This is to certify that Gulf Of Maine Aquarium/Oceanet Associates
has permission to Build New 43,562 sq. Ft. Of Building and Warehouses.
AT 344 Commercial St 042 C001001

Date: November 10, 2003
Architect's Project No.: 03034

**ADDENDUM NO. 4
TO
CONTRACT DRAWINGS AND SPECIFICATIONS
FOR
GULF OF MAINE RESEARCH LABORATORY
Portland, Maine**

N11 CANOPY DETAIL
1-1/2" = 1'-0" AE120, AE311, AE313, AE314 SIM.

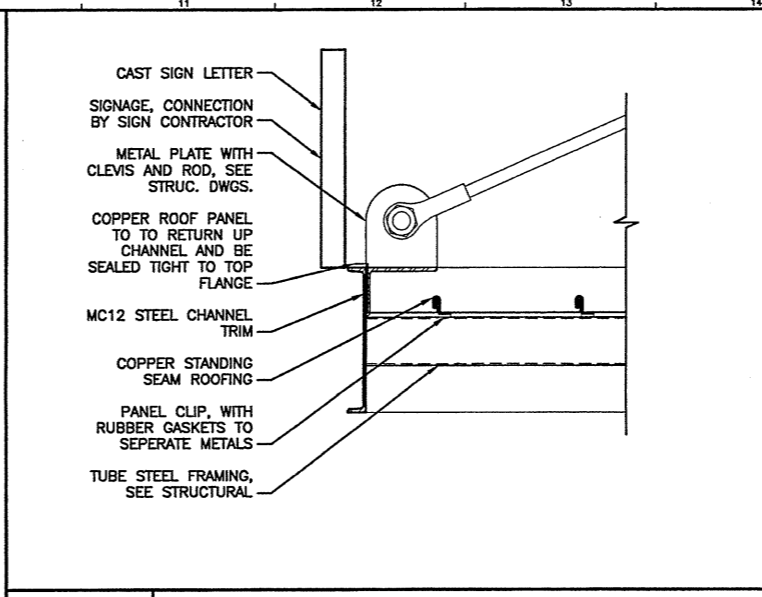
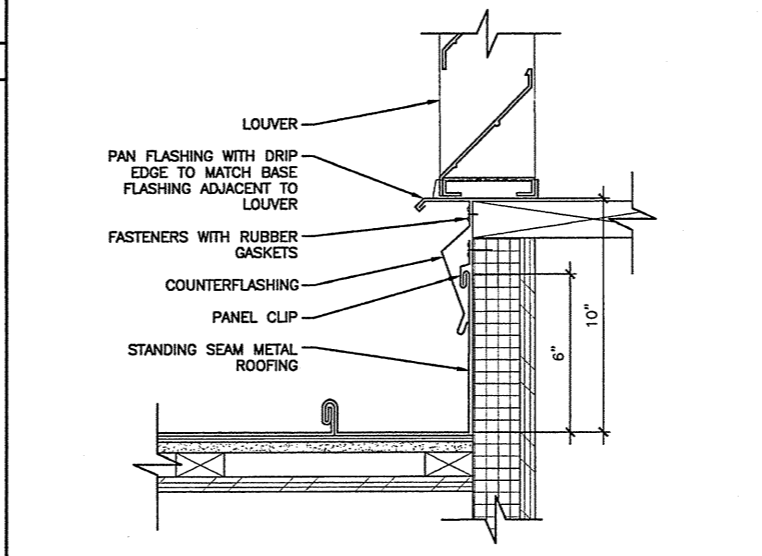
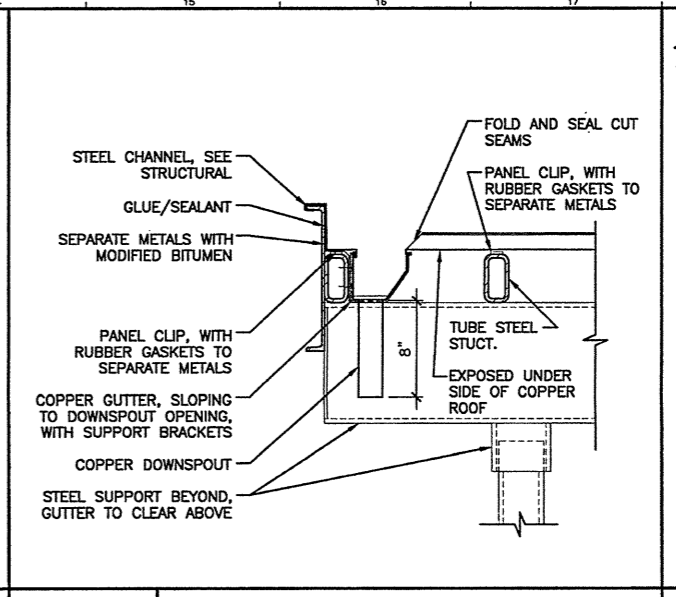
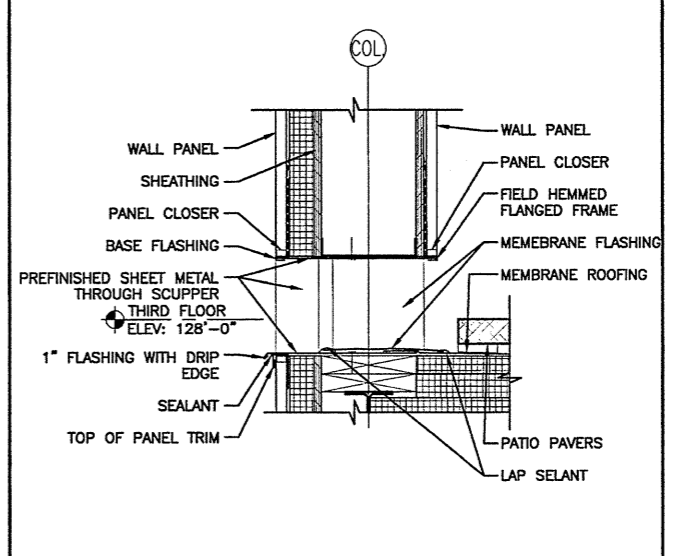
1. There is a plan to show what gets fireproofed however, there are a couple of details such as N11 & J11 on AE521: J1, J4, N11: AE522 which also indicate spray fireproofing on columns as typical. Could you please clarify. *RESPONSE: SF402 correctly shows those areas requiring fire protected columns and beams. Note that where fit of fire-protective spray is tight, rated gypsum board enclosures have been detailed. Note that with increased rating of stair enclosures, sprayed on fireproofing for steel supporting stairway walls must be two-hour. We now propose to use sprayed fireproofing only, and to furr out the walls for fit.*

11. Drawing Sheet AE522, Details N7, N14, J7, J11. Revise to show sprayed on fireproofing on columns. Furr walls as necessary to conceal fire proofing.
